ELLICOTT TOWN CENTER

Filing No. 1

Grading & Erosion Control Plans

El Paso County, Colorado

G2

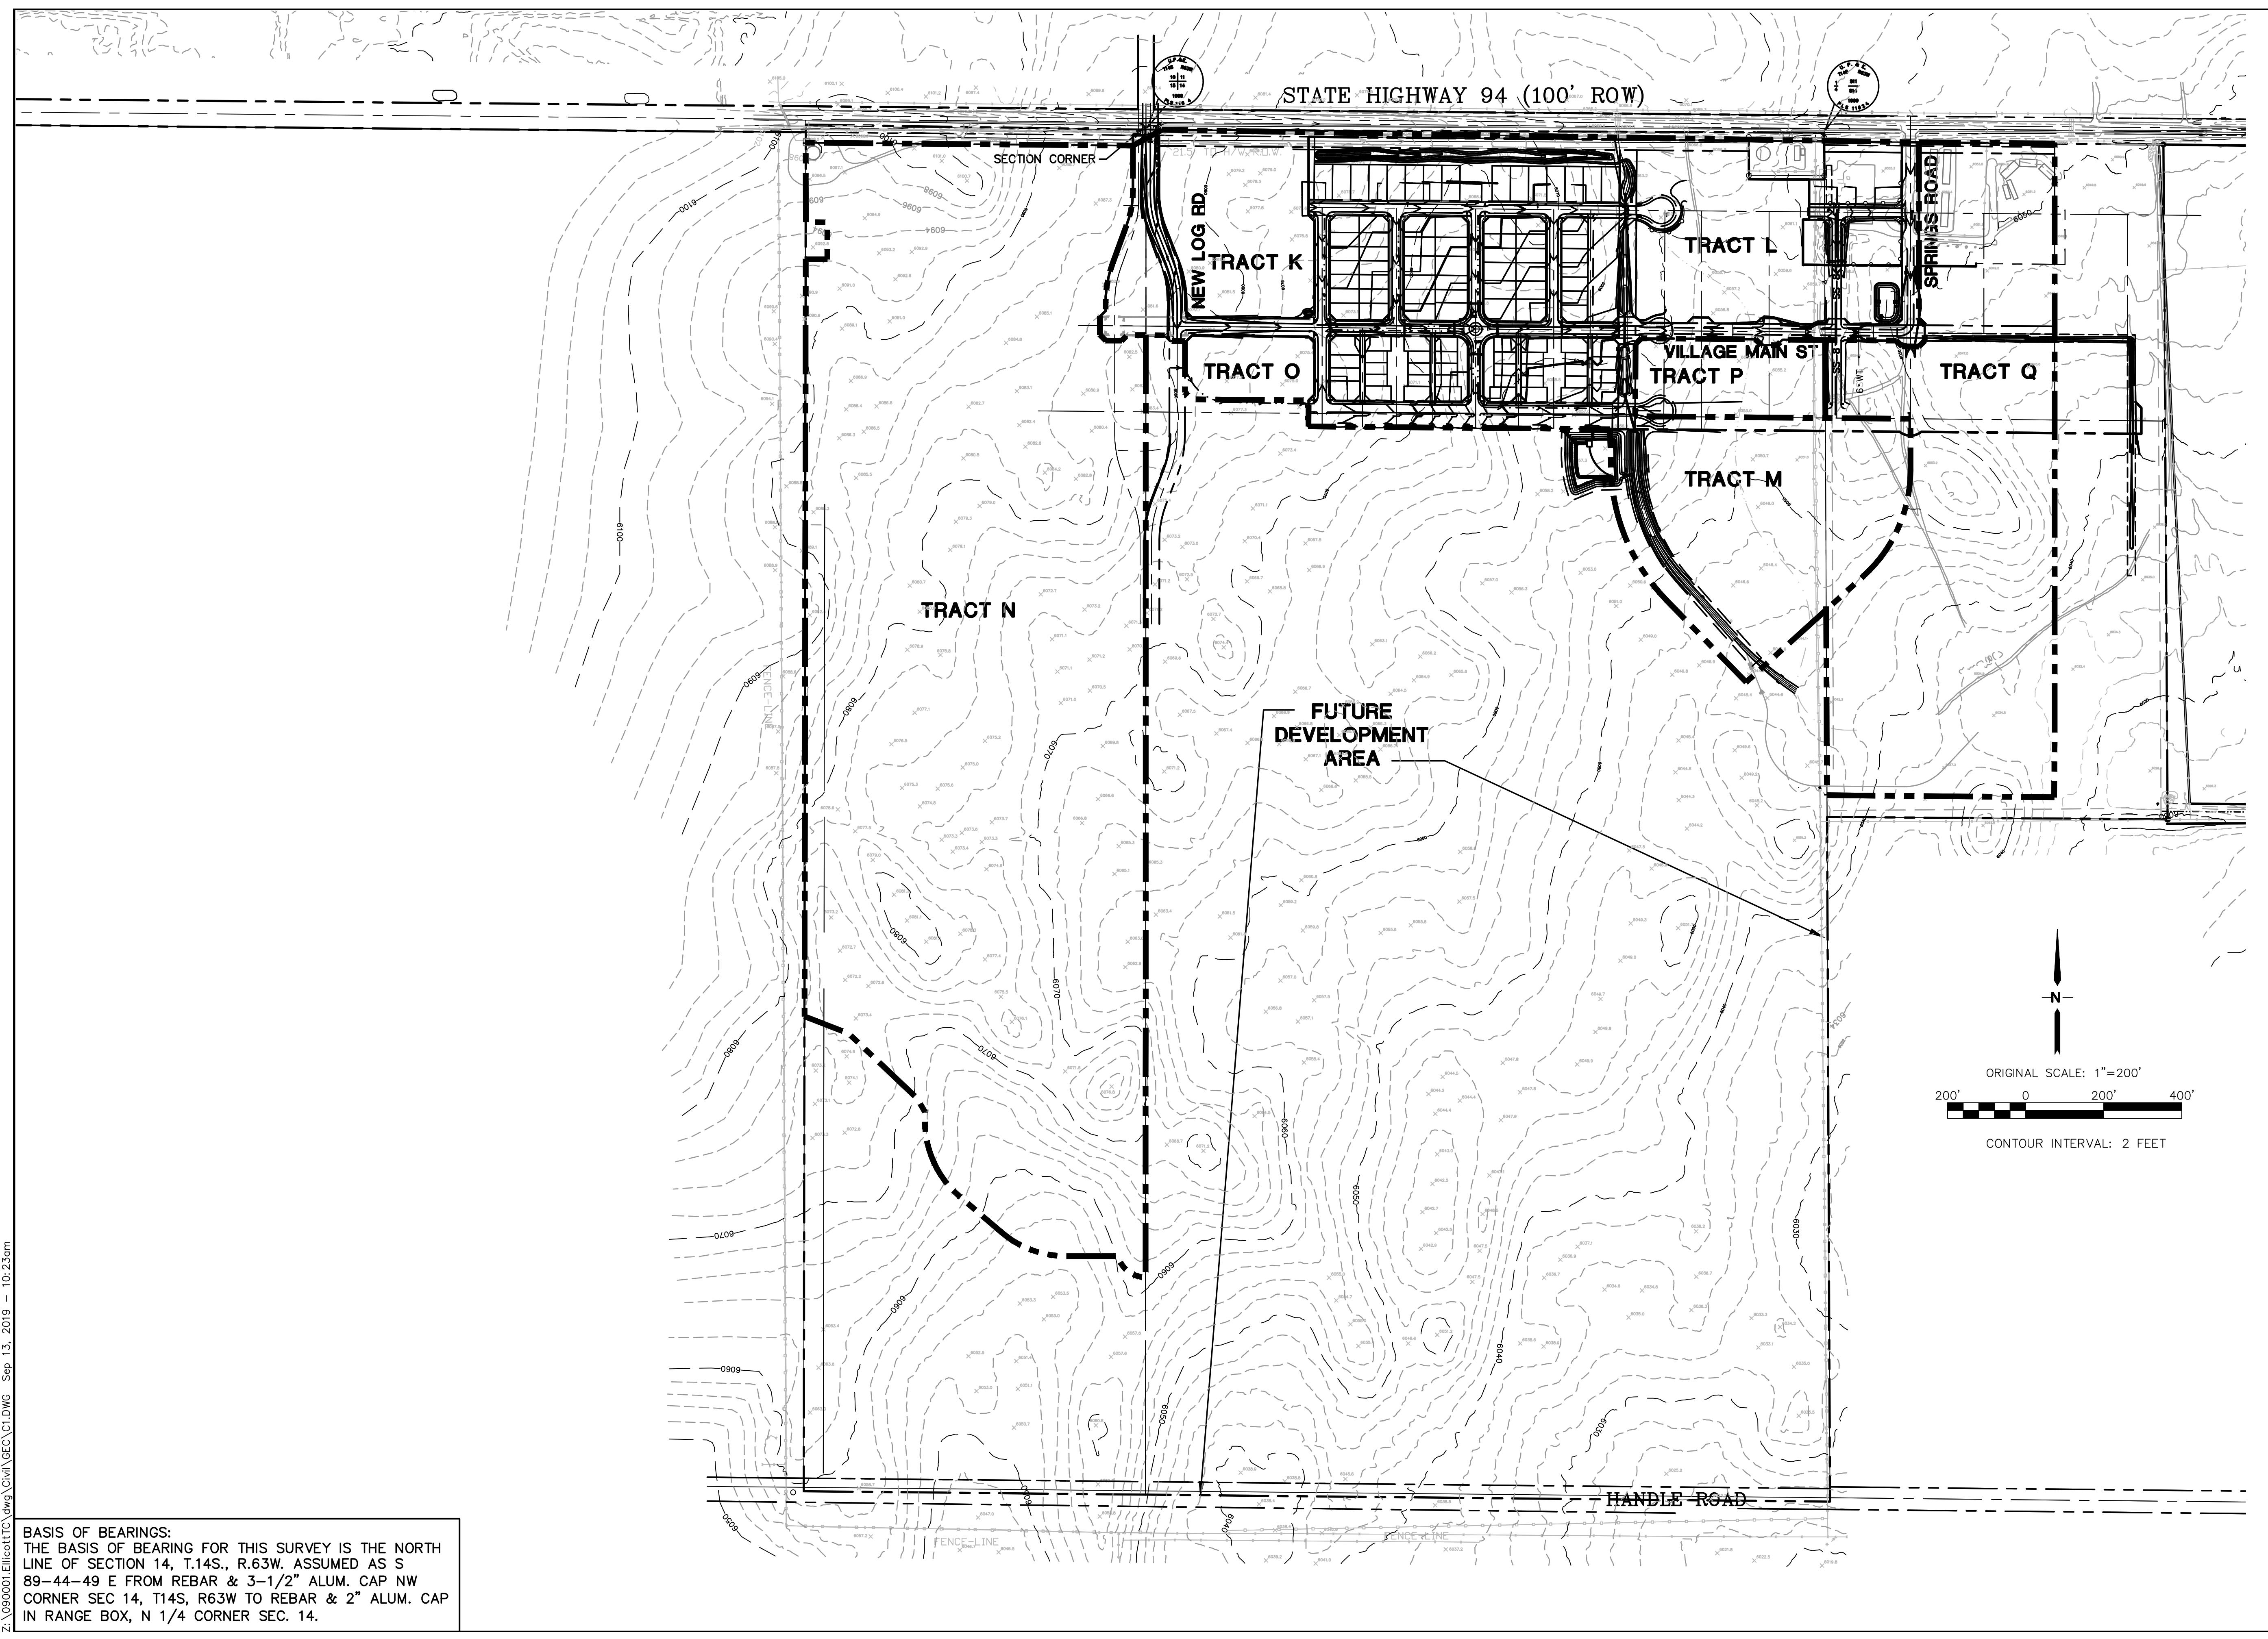
Add: "In accordance with ECM Section 1.12, these construction documents will be valid for construction for a period of 2 years from the date signed by the El Paso County Engineer. If construction has not started within those 2 years the plans will need to be resubmitted for approval, including payment of review fees at the Planning and Community Development Director's discretion."
